Our Ref: AW/143/08/

Proposed extension to music room and lift shaft to first floor - resubmission following
refused application AW/83/08/

15 Waters Edge Aldwick

south 1/100

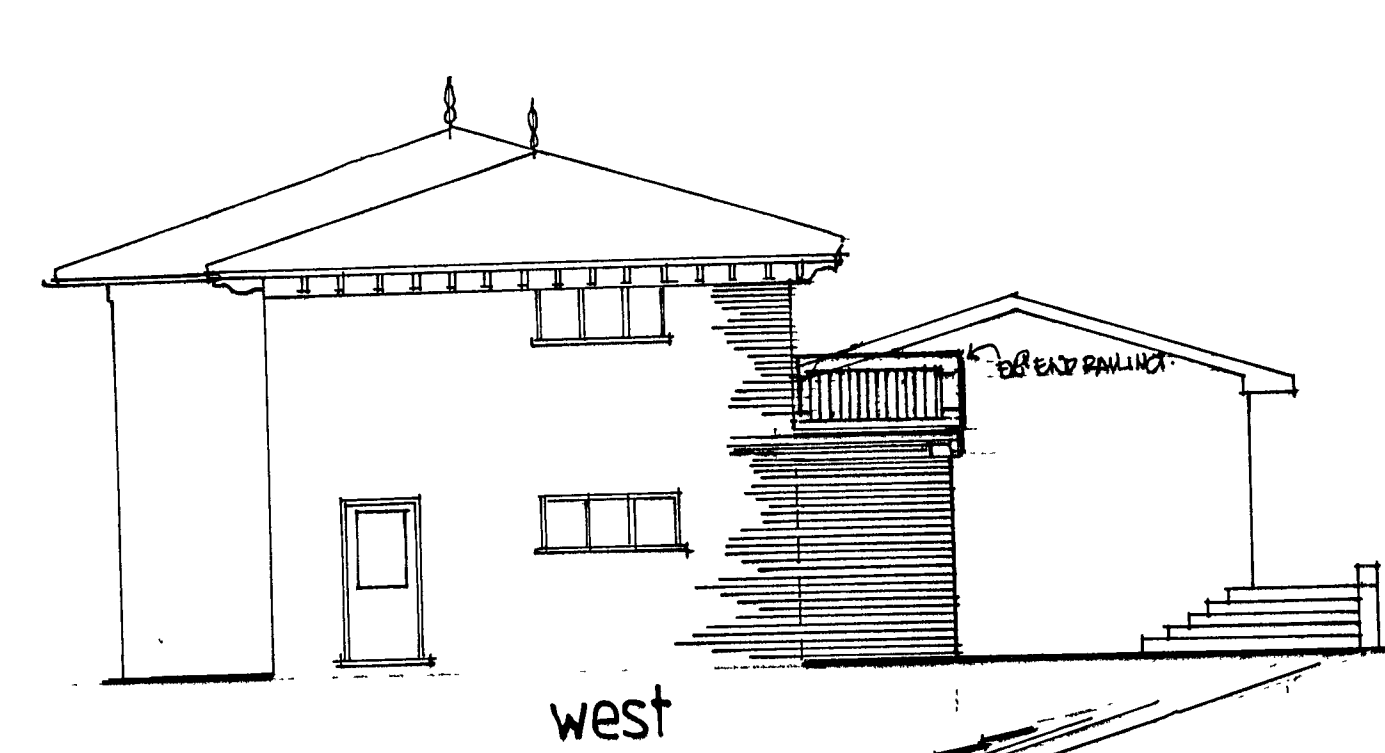
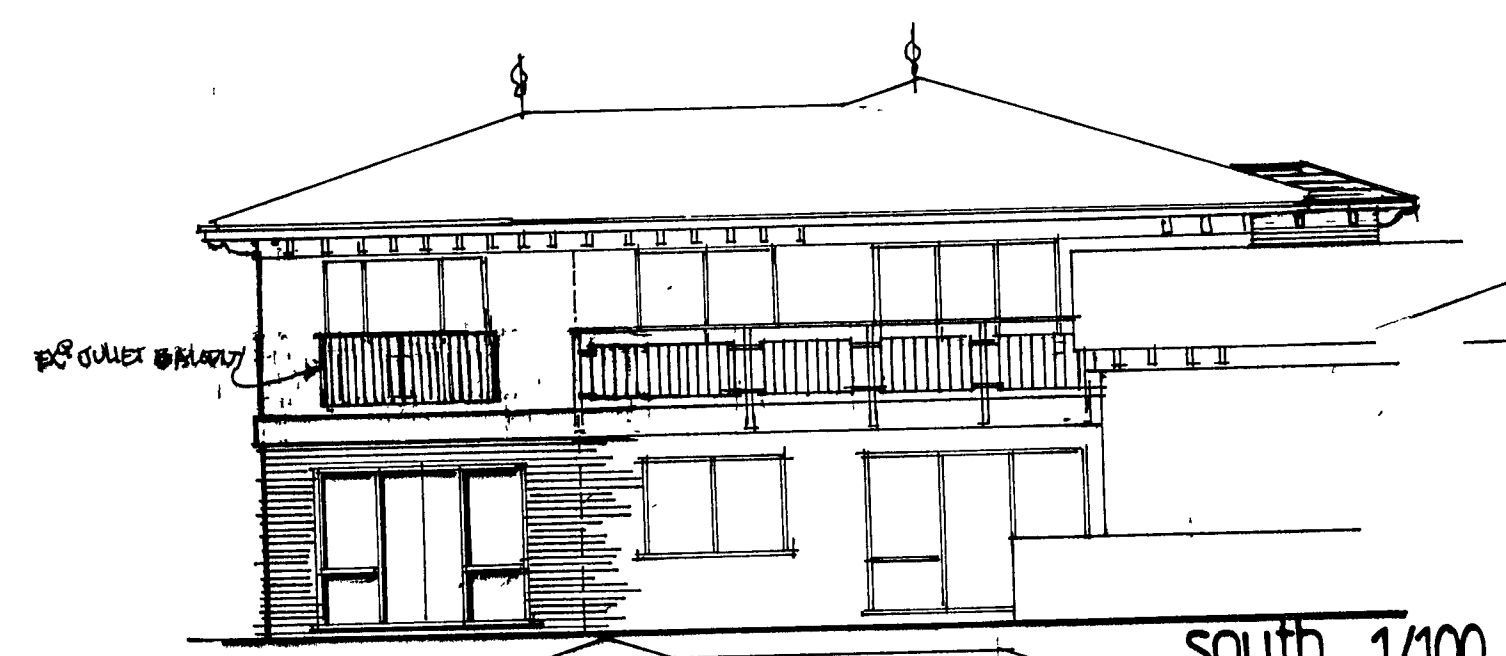
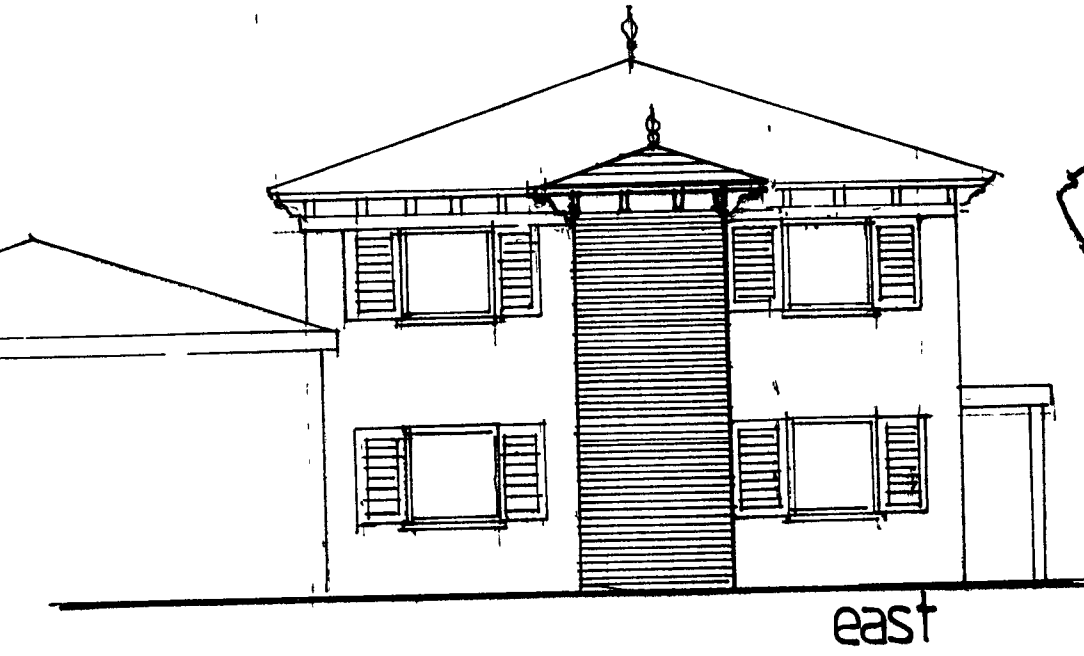
Members believe this development is unneighbourly as there is a possibility of unacceptable overlooking and loss of privacy and likely noise intrusion onto the neighbouring property to the west. Members also thought that the lift shaft and the changed roofline would be out of character with other properties in the locality. ☐
